Peartree Hill Solar Farm

Environmental Statement Addendum Revision ~~3~~² (tracked)

Application Document Ref: EN010157/APP/8.2

~~August-September~~ 2025

Drawing file: published-documents / EN010157-000571-6.3 Environmental Statement Volume 3 Figure 14.3 Public Rights of Way Within and Adjacent to the Proposed Development Revi

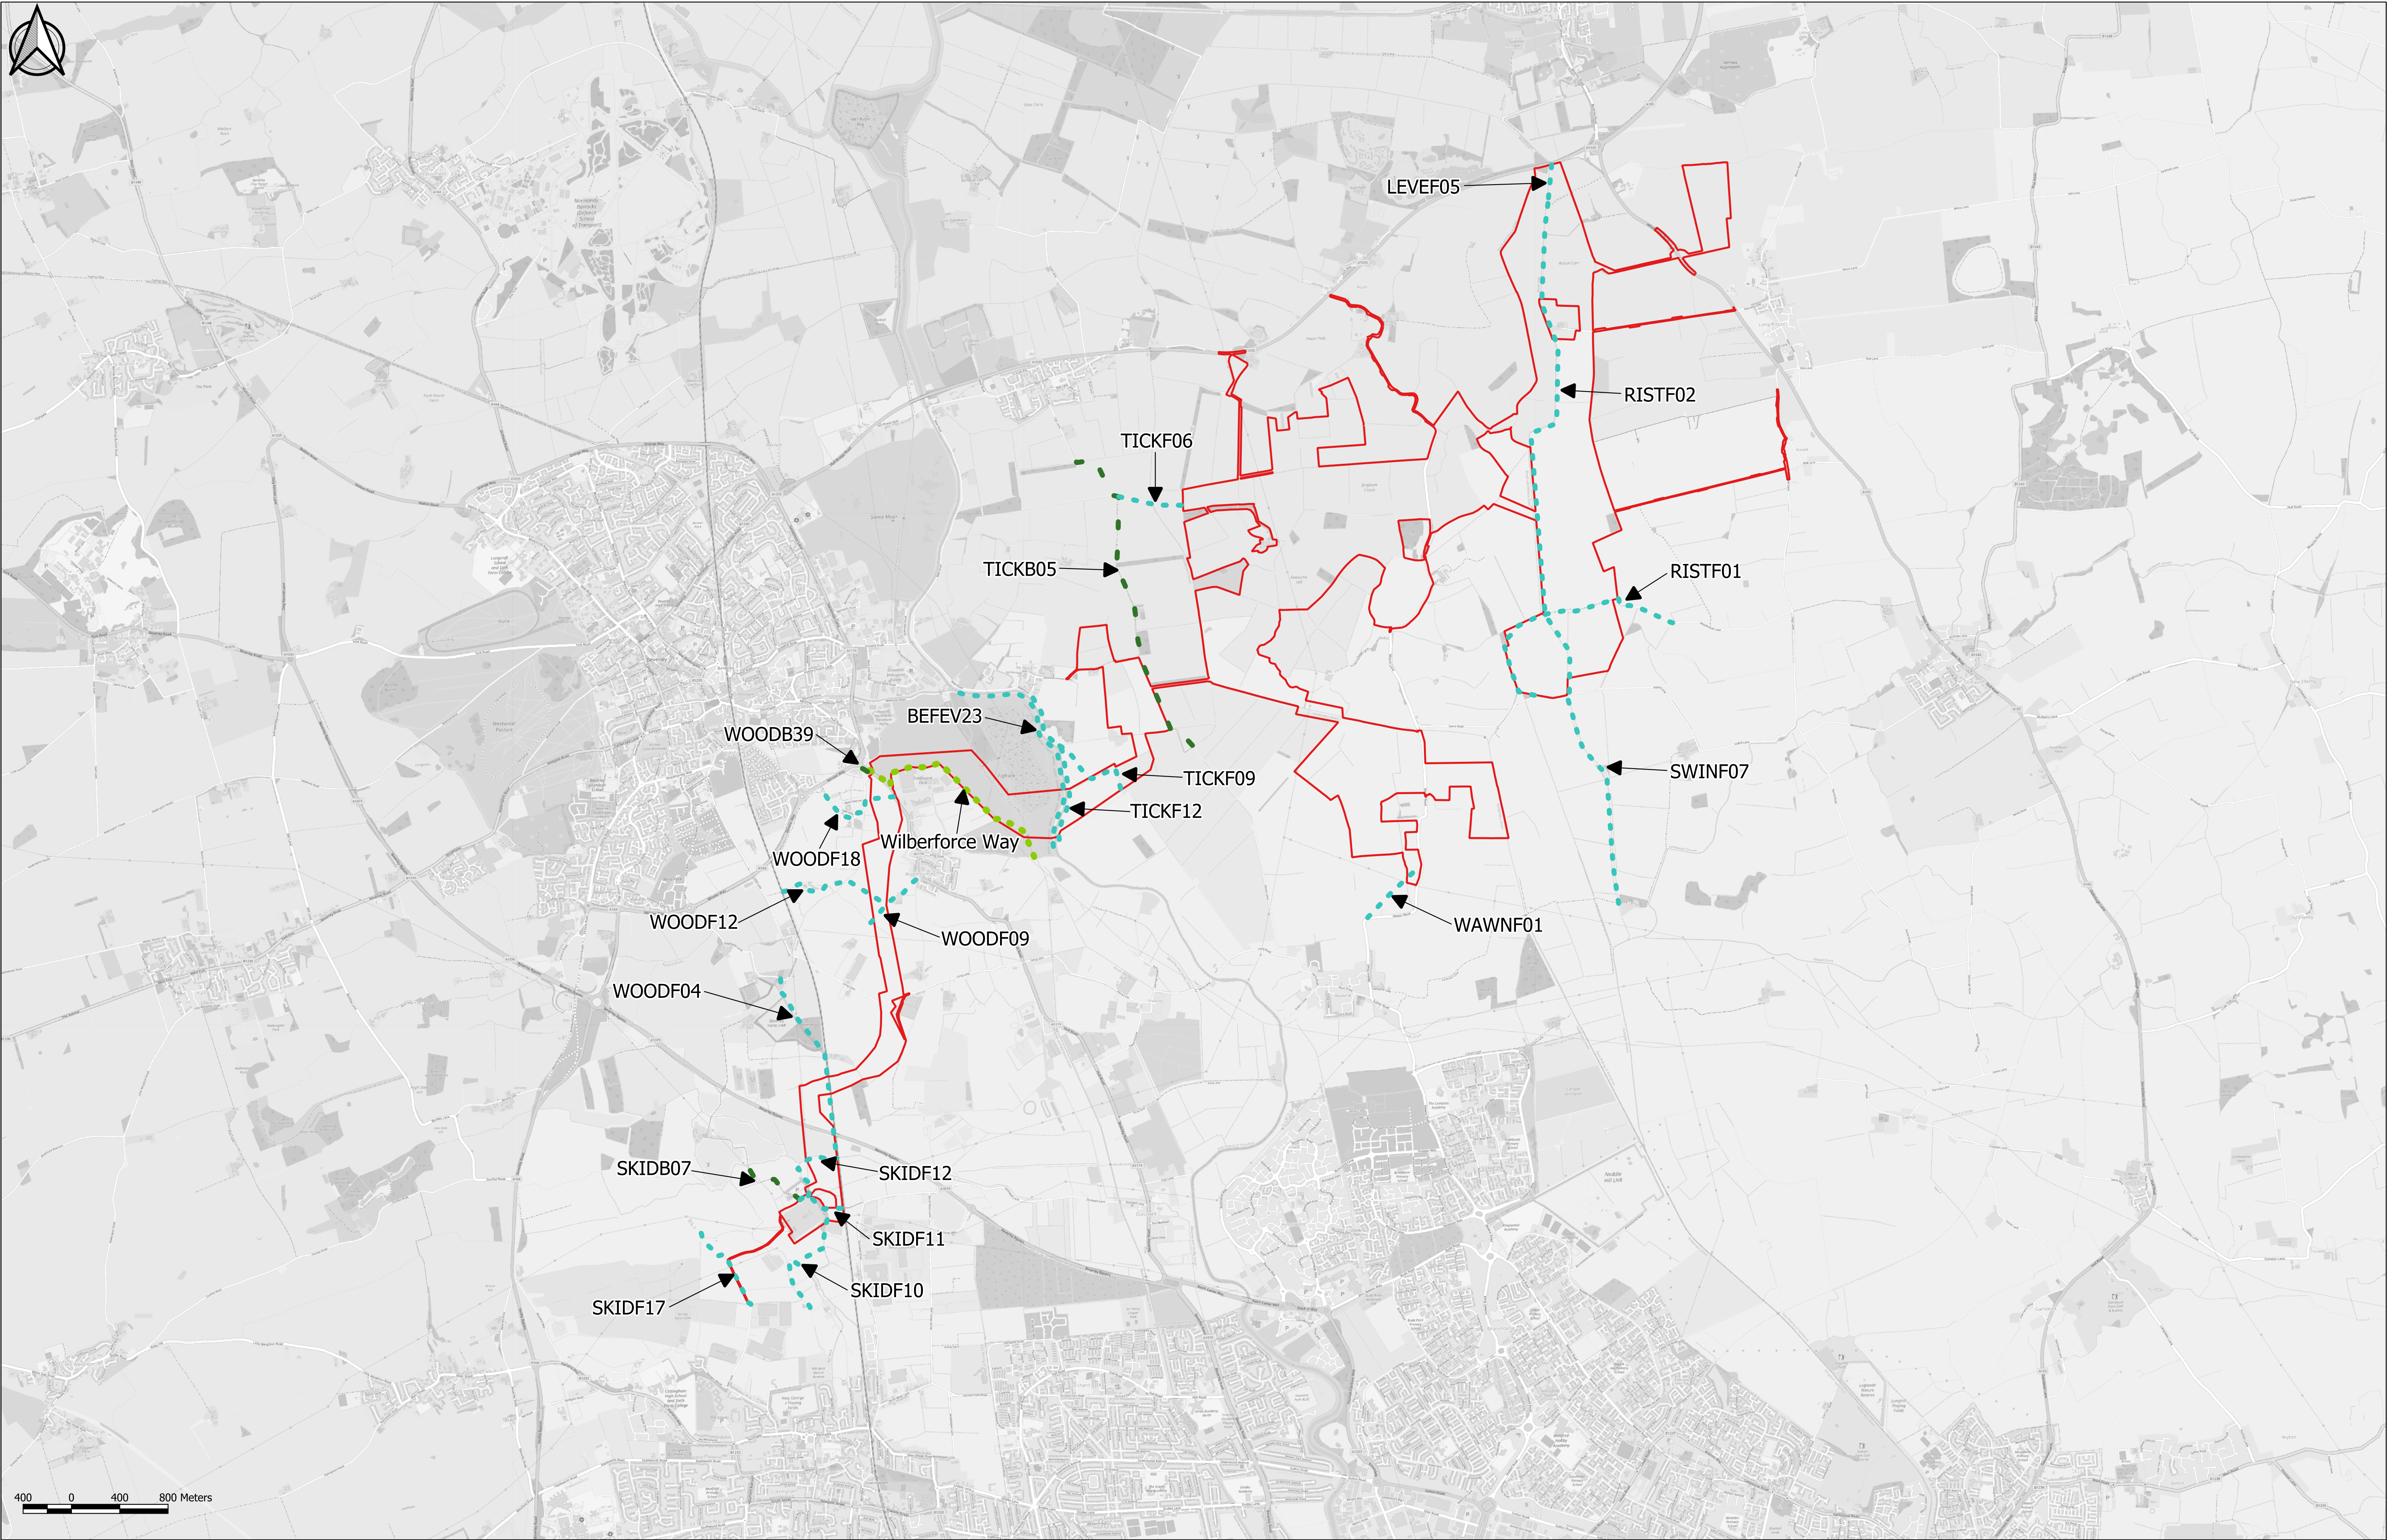
Document reference	Reason for amendment	ES Amendment July 2025
ES Volume 3, Figure 14.3: Public Rights of Way and Long Distance Paths Within and Adjacent to the Proposed Development [APP-091]	Figure 14.3 requires amendment to reflect the removal of plots 10-4, 10-5 and 10-6 as part of change/correction 2.	
ES Volume 3, Figure 14.4: Link Sensitivity [APP-092]	Figure 14.4 requires amendment to reflect the removal of plots 10-4, 10-5 and 10-6 as part of change/correction 2.	
ES Volume 3, Figure 15.1: Other Existing and/or Approved Development [APP-093]	Figure 15.1 requires amendment to reflect the removal of plots 10-4, 10-5 and 10-6 as part of change/correction 2.
